CITY OF ALBUQUERQUE

RE: 8920 Oakridge Court
Grading Plan
Stamp Date: 6/27/17
Hydrology File: C20D077

Based upon the information provided in your submittal received 6/27/2017, the Grading Plan **is not** approved for Building Permit. The following comments need to be addressed for approval of the above referenced project:

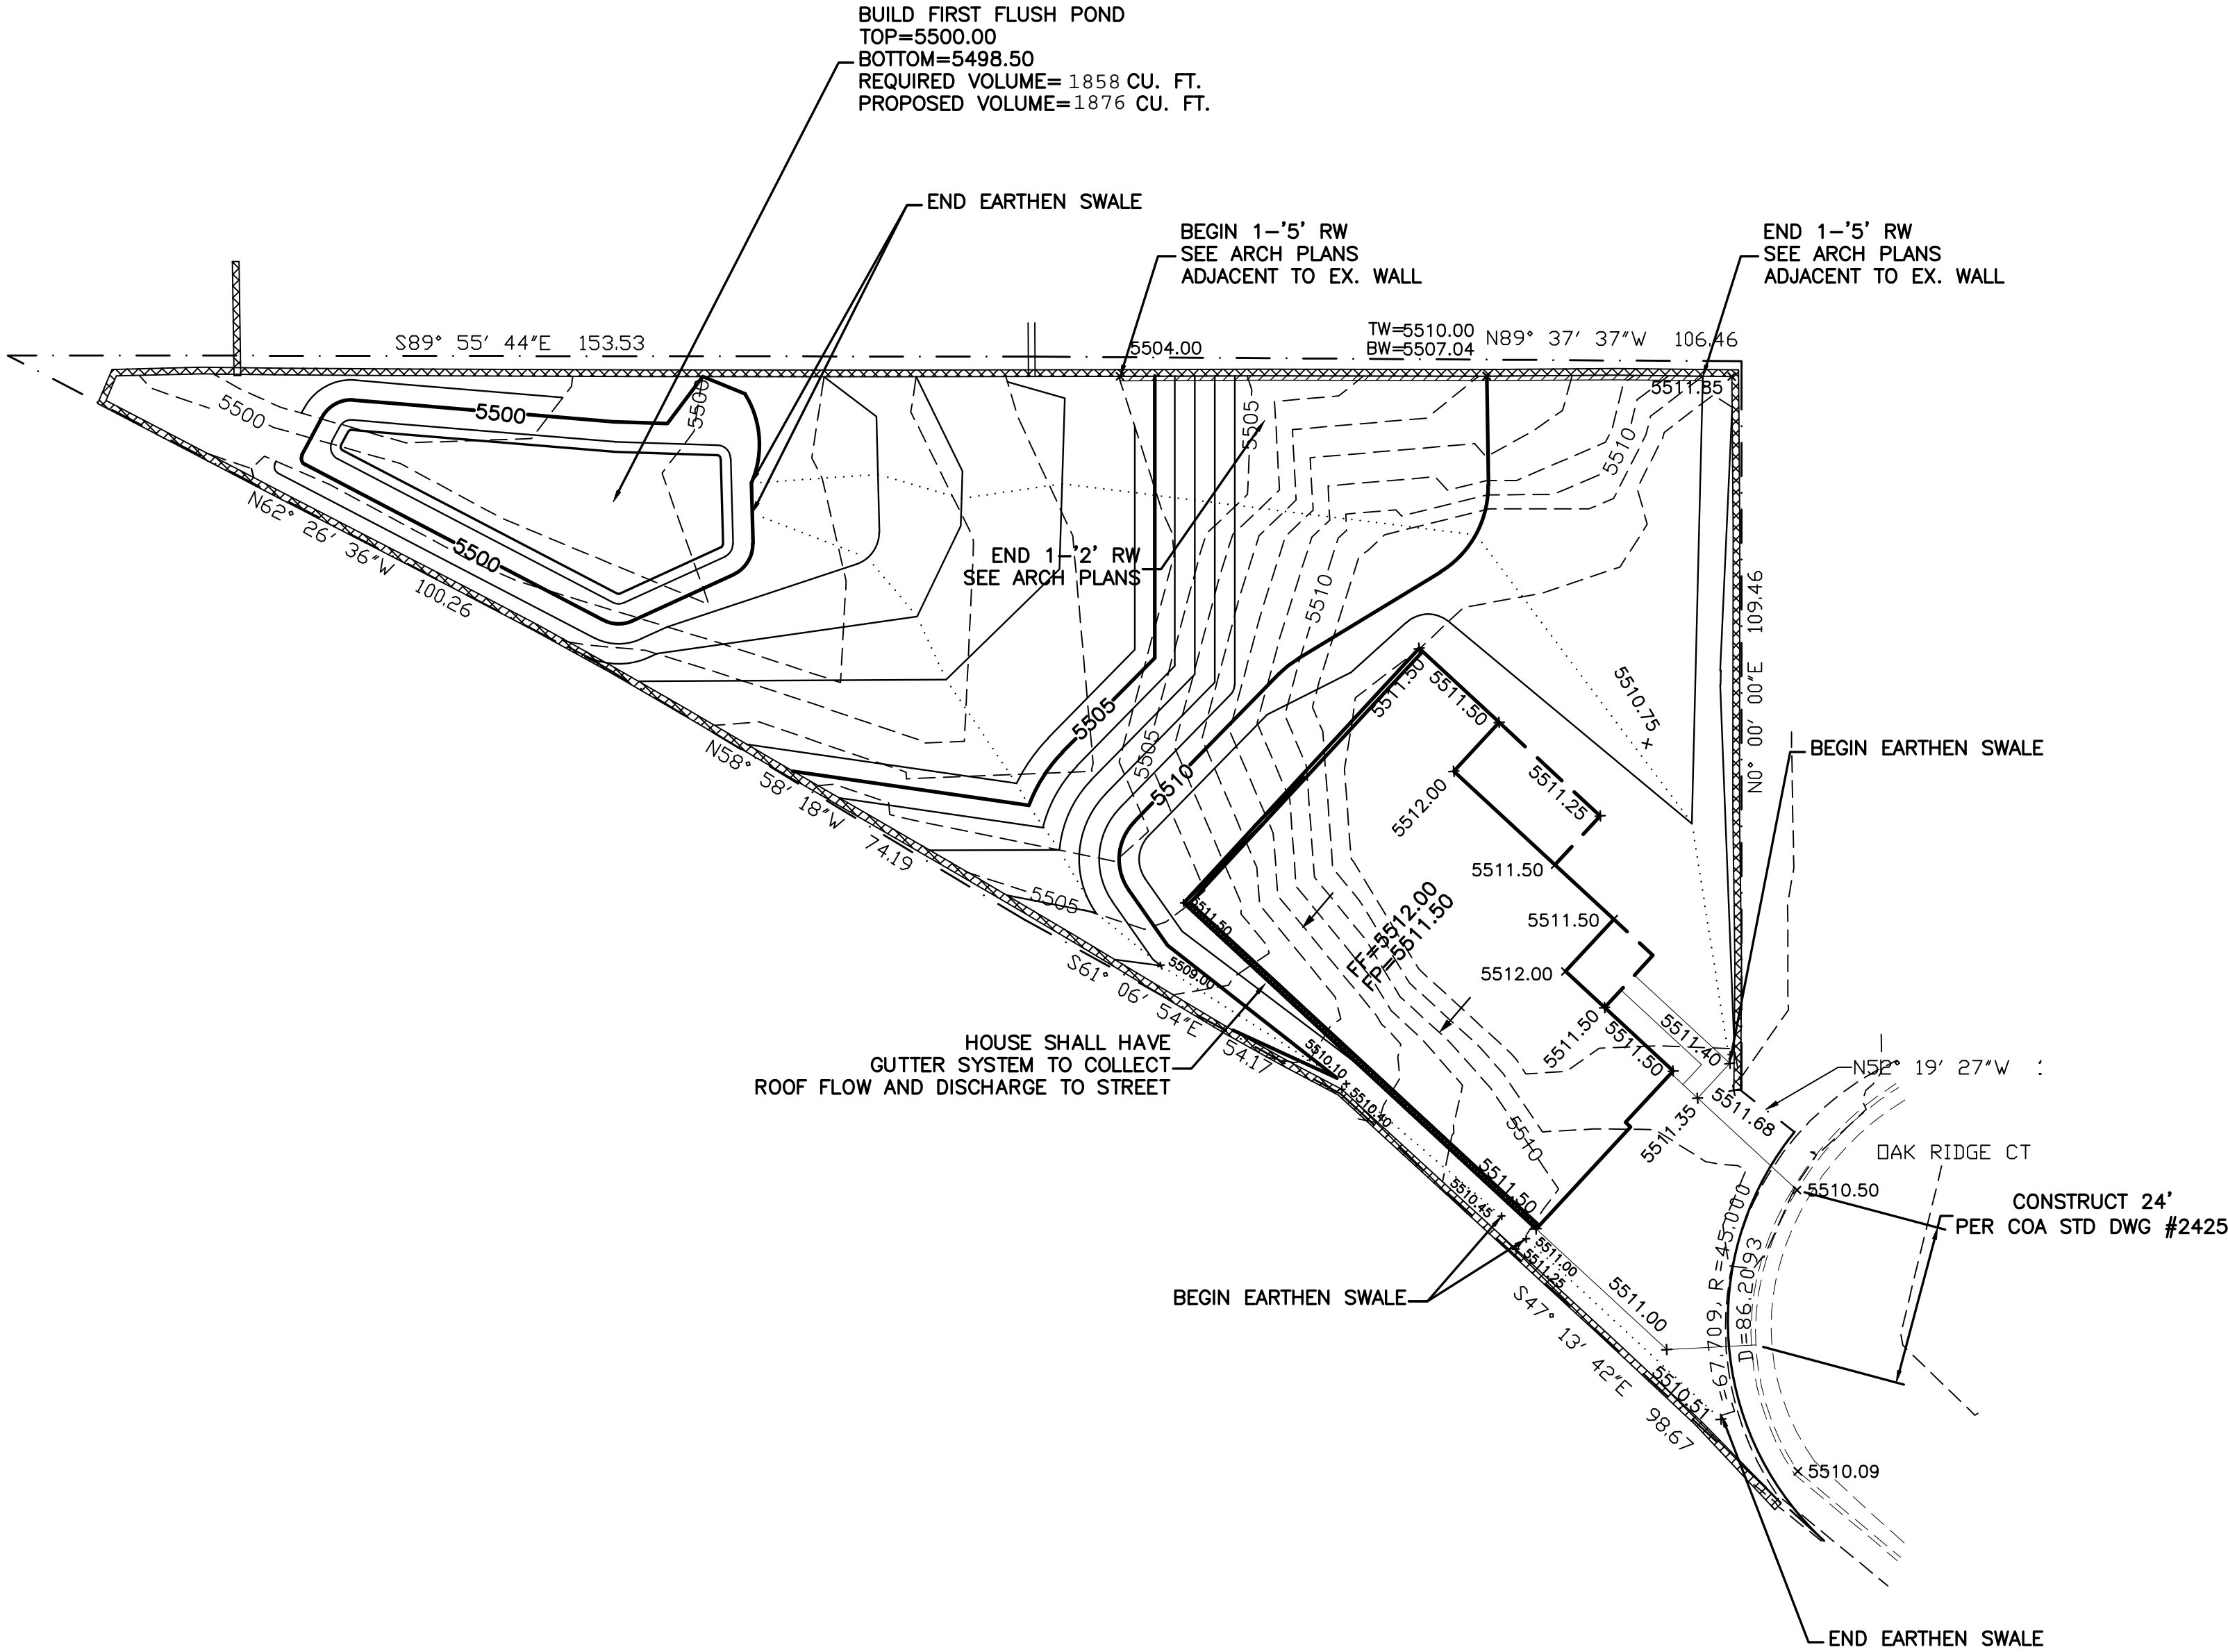
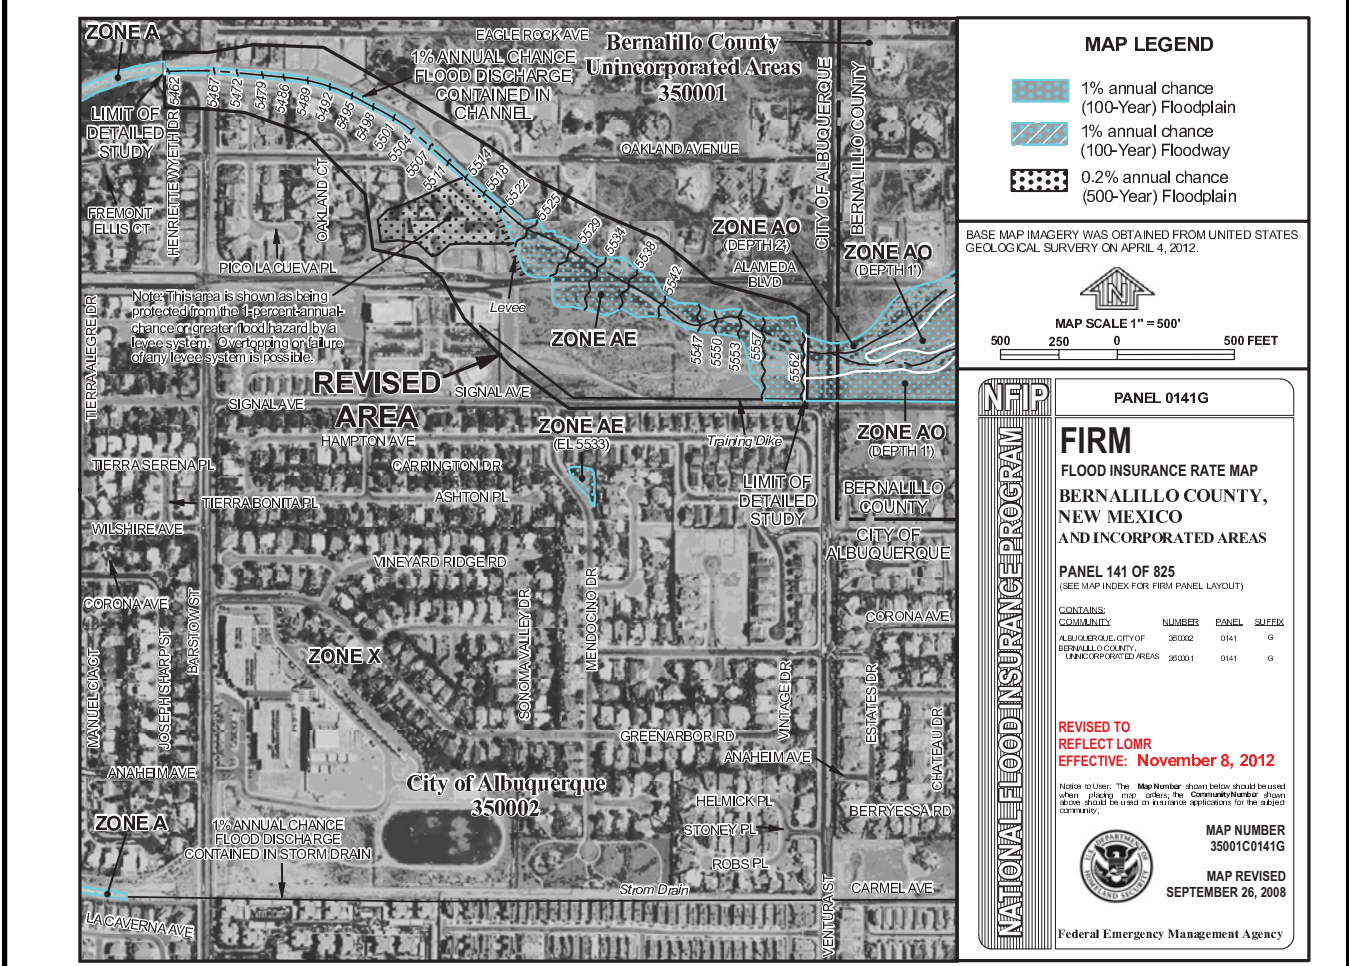
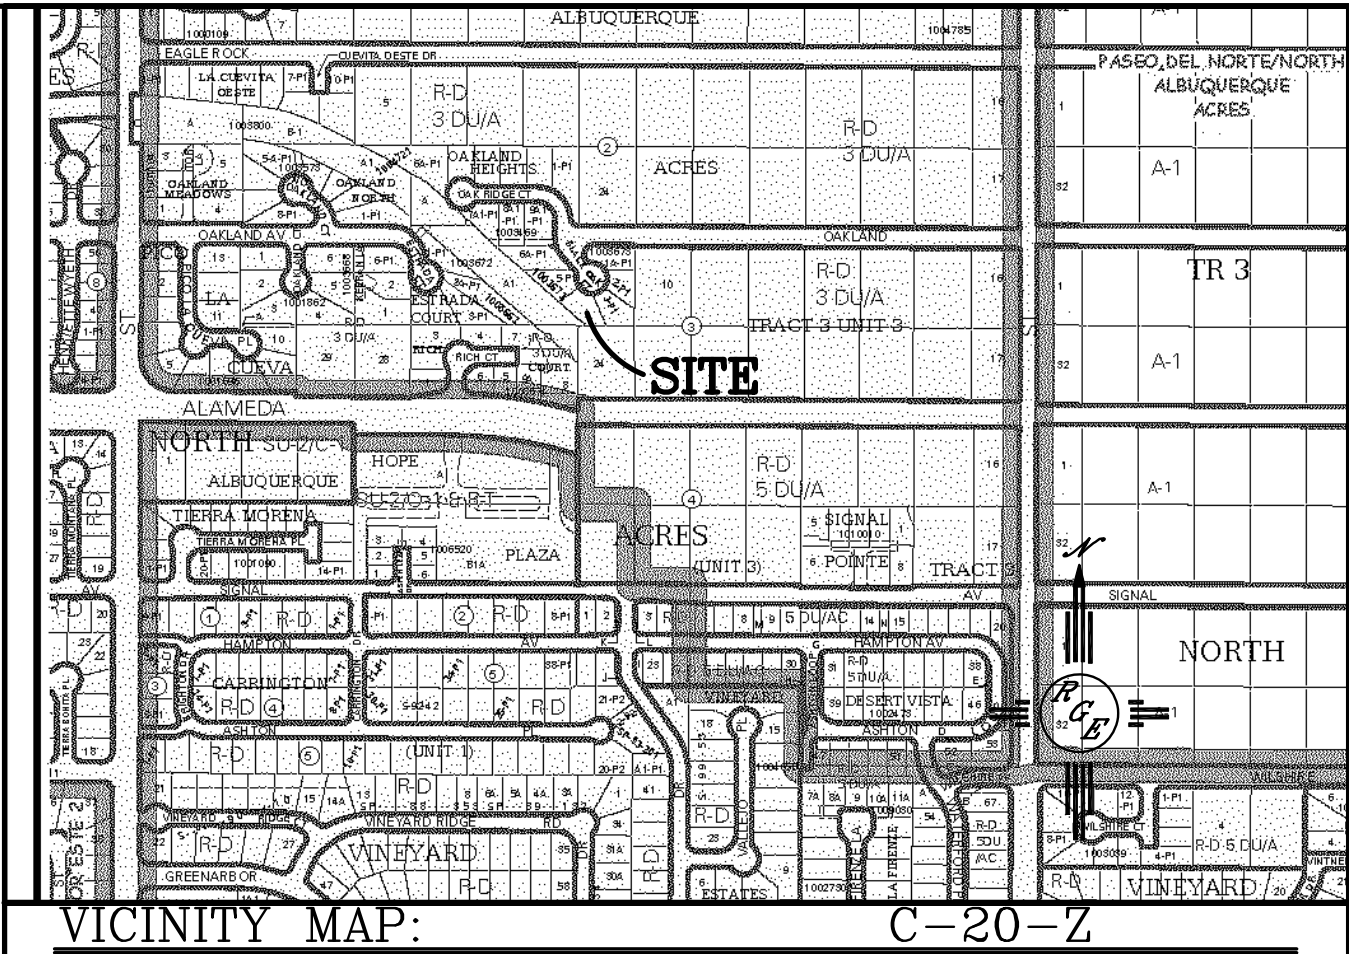
1. Please provide the description "La Cueva Channel (maintained by AMAFCA)" to the tract to the southwest of the property.
2. Since the site drains into the La Cueva Channel, approval by AMAFCA will be need prior to Hydrology approval. Please contact Bradley Bingham, PE at (505) 884-2215 or bbingham@amafca.org.
